From: Sue Howell <Sue.Howell@arun.gov.uk>
Sent: 13 February 2025 18:43
To: Planning.Responses <Planning.Responses@arun.gov.uk>
Cc: Simon Davis <Simon.Davis@arun.gov.uk>
Subject: Planning Consultation on: AL/137/24/RES

Response to Planning Application

Application ref: AL/137/24/RES

Description: Approval of reserved matters following outline consent AL/178/22/OUT for appearance, landscaping, layout and scale for 89 No. dwellings with open space and associated works (resubmission following AL/50/24/RES). This application is in CIL Zone 3.

## LEAP

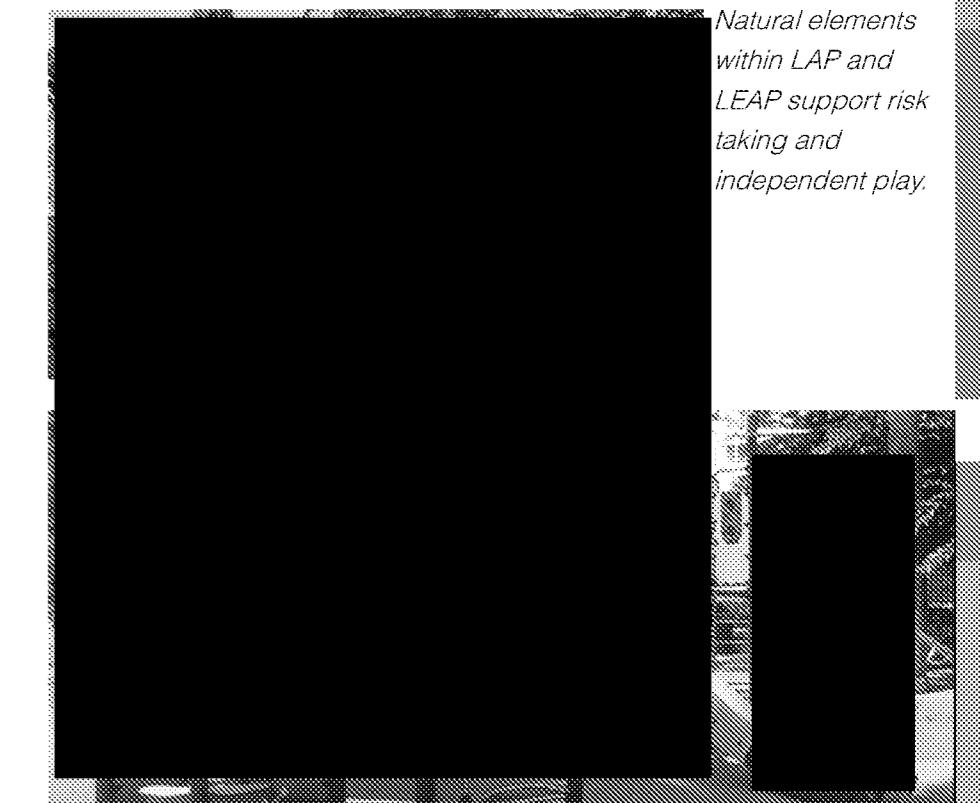
PLAY - As previously advised this development triggers the requirement for play in the form of onsite LAPs (more than 1no) and LEAP provision, which need to be suitable for location in material

choice and play experience offer. Play is referenced to be detailed within Play dwg D3370-FAB-00-XX-DR-L-2003 and further detailed within Detailed Play area LAP and LEAP D3370-FAB-00-XX-DR-L-2003 REV PL01. The play proposed falls below the standard that would be required and within our Design Guide requirements. The play offer proposes only 1no LAP and 1no LEAP combined, with limited specification of the proposals. The play offer needs to provide inclusive and accessible play, providing an exciting and challenging offer with a good variety of play experiences. The list of play items indicated within the D3370-FAB-00-XX-DR-L-2003 REV PL04 dwg falls short on provision and specification, falls down on quantum and location and general play detail. Self-binding gravel destination pathways are not supported, requiring all weather macadam pathways for these high trafficked routes.

The play detail including further LAP provision needs detailed submission to include specification of play proposed, surfacing, fencing, street furniture, bins, pathway connection and pathway surfacing detail. 2no x LAP 1no x LEAP.

## PROPOSALS

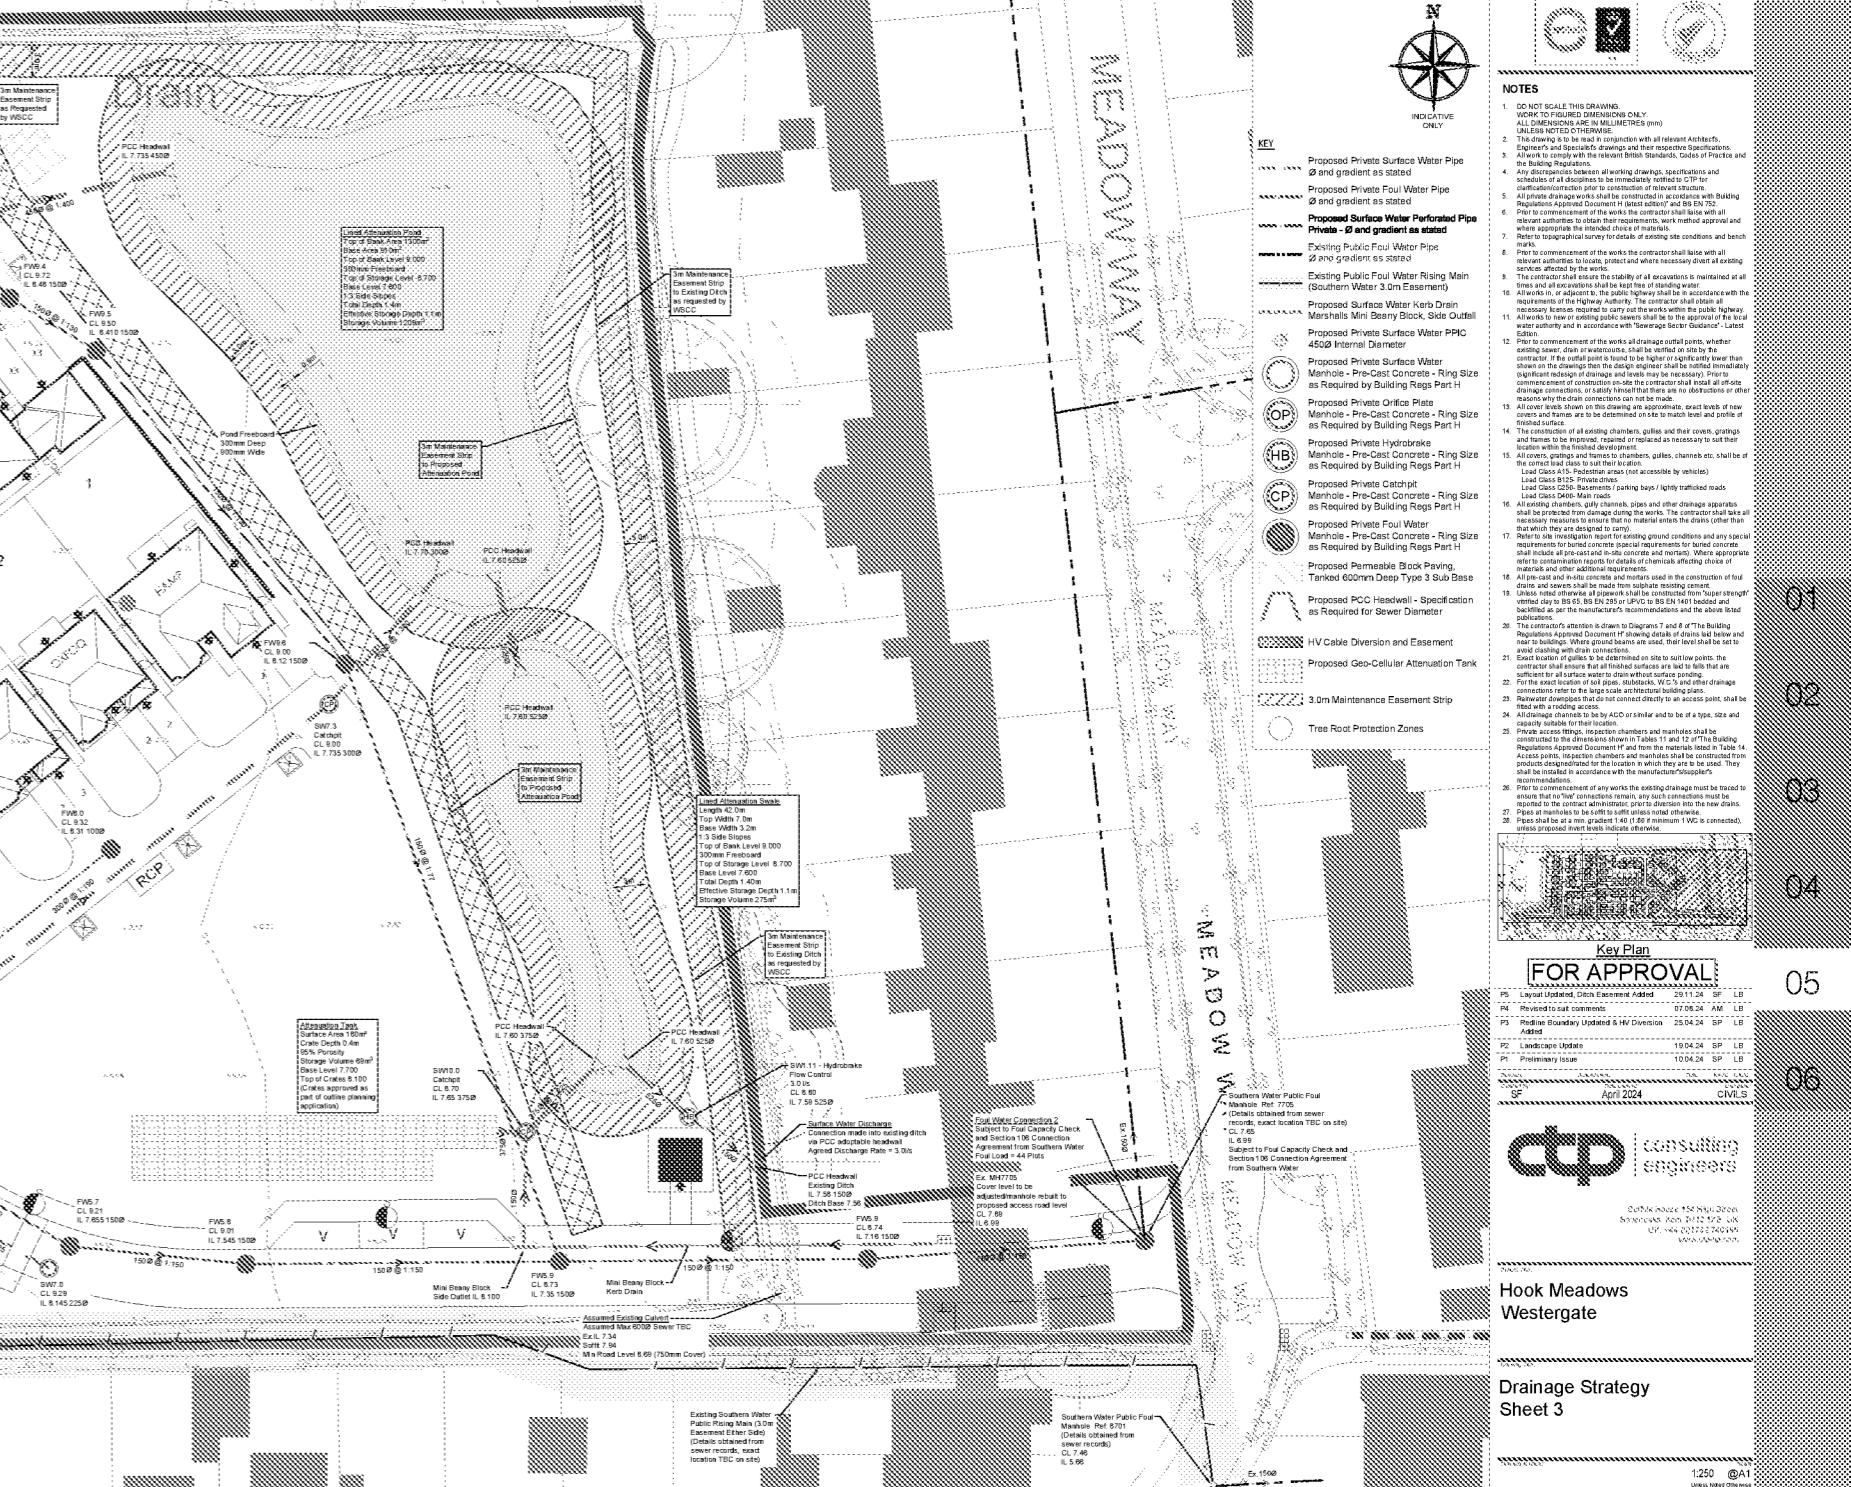
The submitted Design and Access Statement Part 3, P35 also states that *A large space for an attenuation basin with swale extension has been retained in the northeast corner of the site. It is intended to retain a permanently wetted area within the infiltration basin so that biodiversity and visual amenity benefits can be created.* A permanently wetted area would not then allow for it to be used as accessible usable POS and therefore should not be included within the POS calculations.

Due to the POS being shown as SuDS area provision, then this also then remains featureless and tree devoid except for perimeter planting which would not be conducive to the formation of an attractive POS area. POS areas need to connect within and beyond the development site, provide biodiversity enhancement opportunities with integrated tree planting and buffer areas which should form attractive welcoming spaces, softening and integrating the proposals with the existing residential development on this fringe.
